P/49/11.

Drawing 02
June 2011

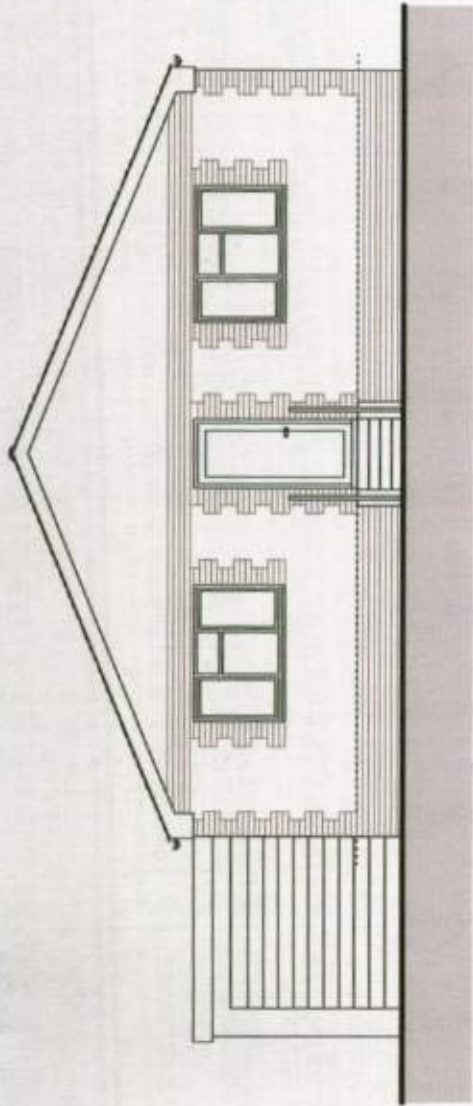
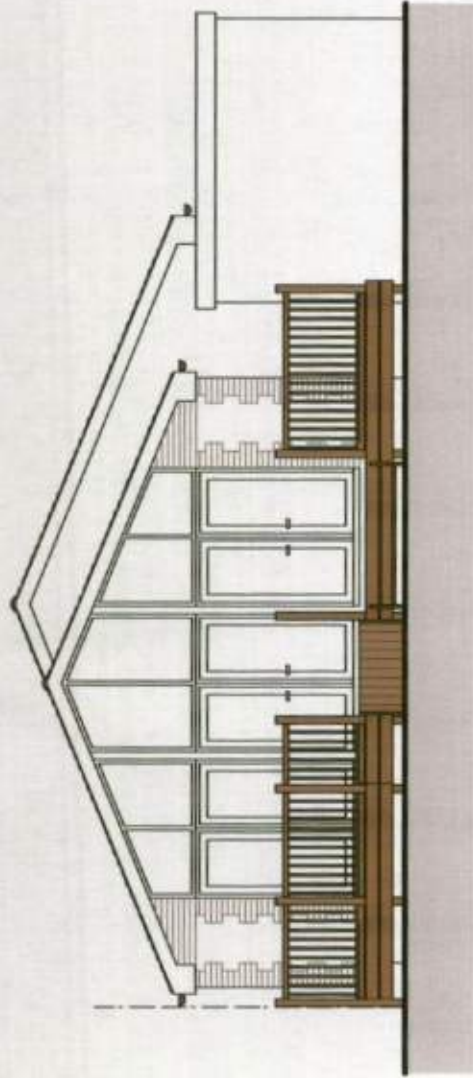
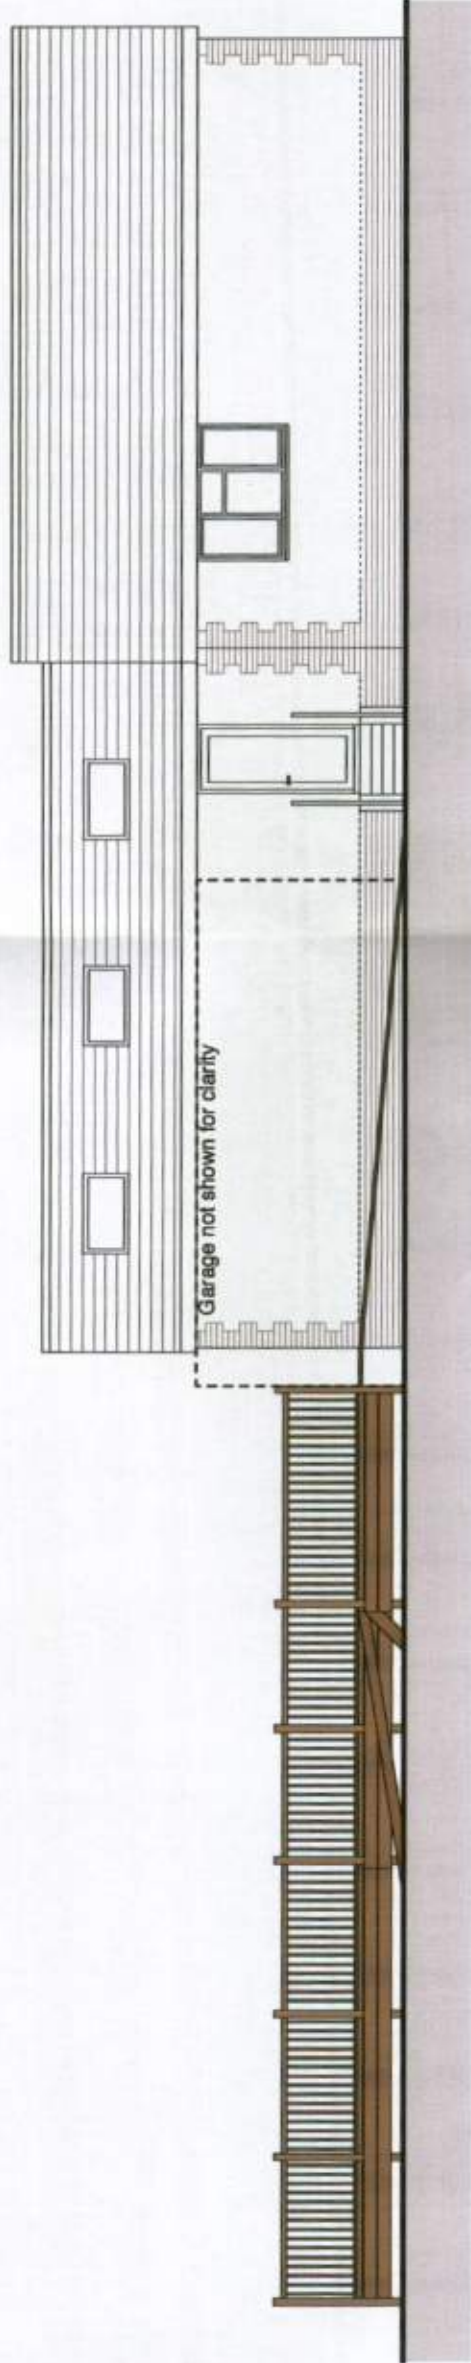
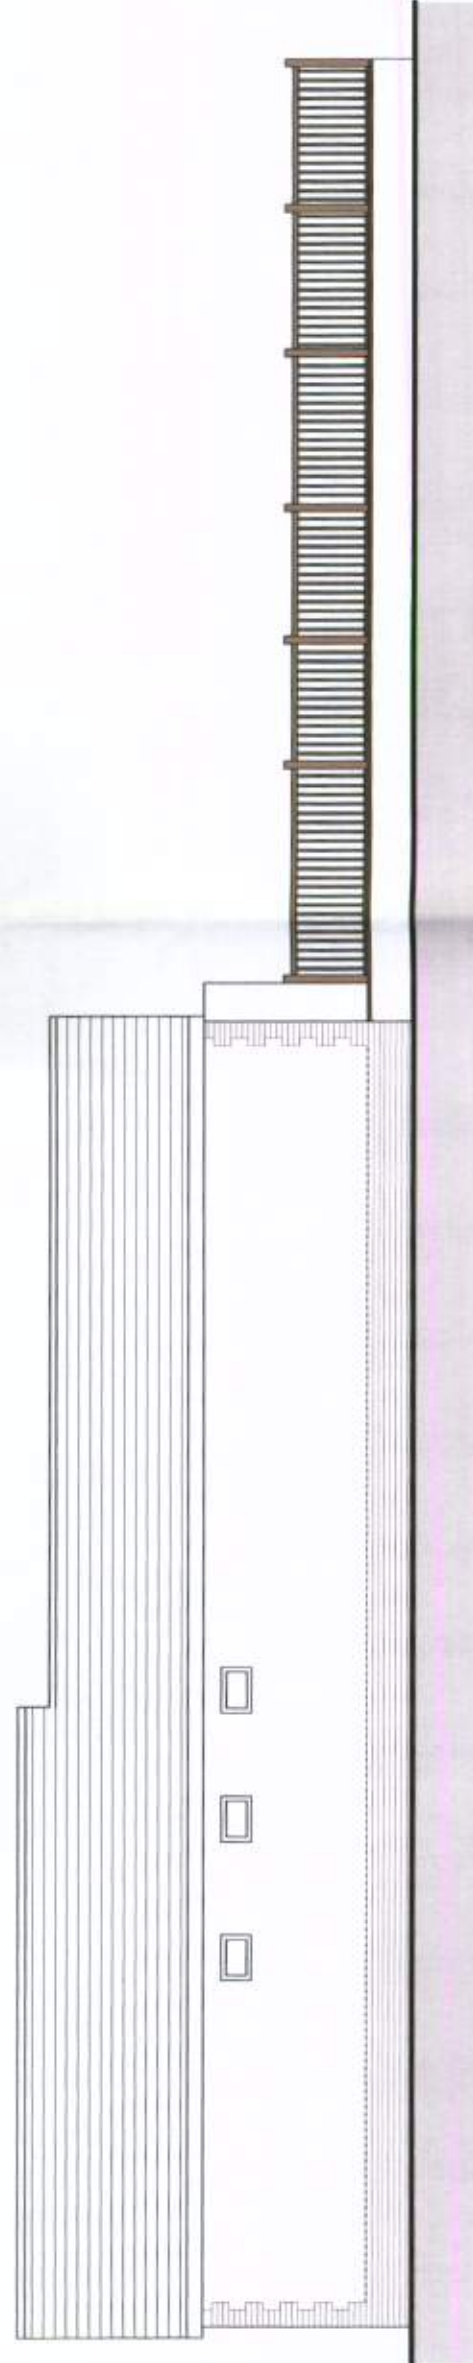
The high fences at the back of the property block my view of the nature reserve and its the only garden with such high fences. Also when people are sitting on the raised decking, its elovated position means that the sound travels further. It sounds like people are actually in my garden and i can hear every word.
